Rezoning Transportation Analysis

Petition Number: #2022-111

Revision Log:

Date	Description
11-28-22	First Review (PDM)
12-22-22	Second Review (DR)
01-25-23	Third Review (PDM)

DSG PROPERTIES, LLC  
PARCEL: 05325113  
DB: 32275 PG. 944  
LAND USE: VACANT  
EX. ZONING: I-1 (CD)  
PENDING REZONING: 2021-284 (I-1 (CD))

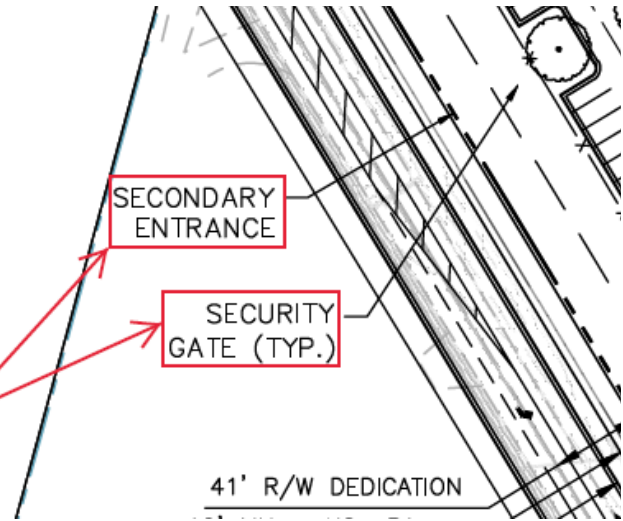
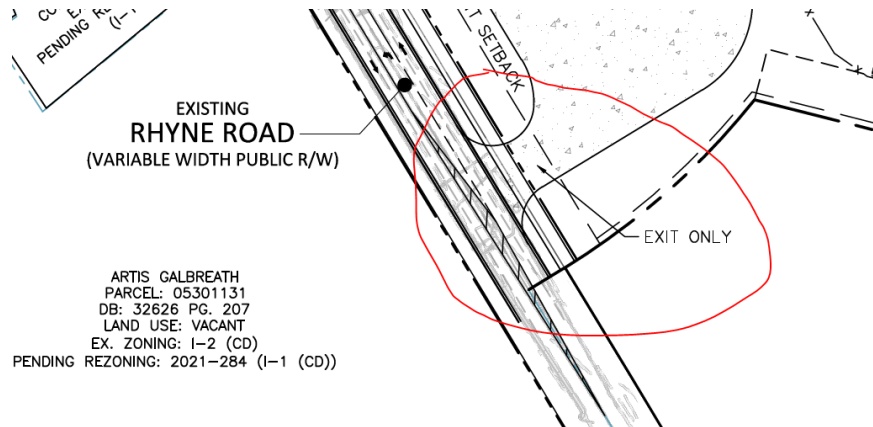
Remove callouts for security gate and secondary entrance. Don't look like they are needed here anymore.

8. ~~New Comment from 12/22/2022:~~ The exit only driveway needs to be reconfigured to prevent potential ingress traffic or removed altogether.
